**Rezoning Transportation Analysis**  
**Petition Number: Insert Zoning Petition #2021-032**  
*General Location Identifier: Tax ID 06912627*

Revision Log:	Date	Description
	02-25-21	First Review (EL)
	03-24-21	Second Review (EL)

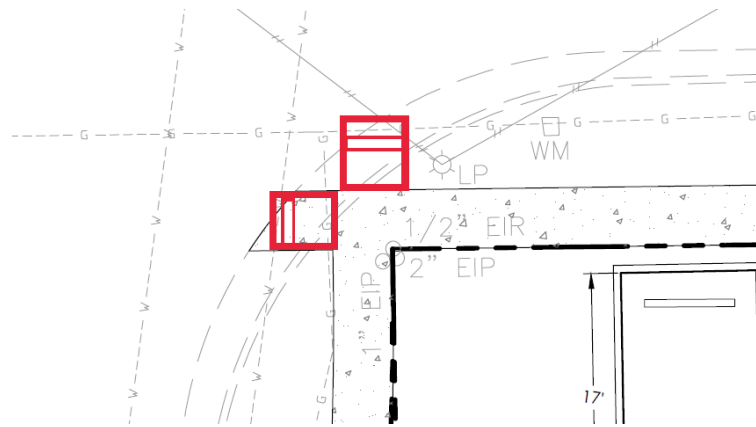
1. ~~**Curblines:** The proposed zoning district has a setback measured from back of the existing or proposed future curblines.~~
  - a. ~~**LaSalle Street:** The future location of curb and gutter needs to be moved 5 feet from its existing location to accommodate a 5-foot bike lane, per the West End Land Use & Pedestrian Plan (see cross-section below).~~

Label and dimension the curb and gutter from the centerline for each road on the site plan.
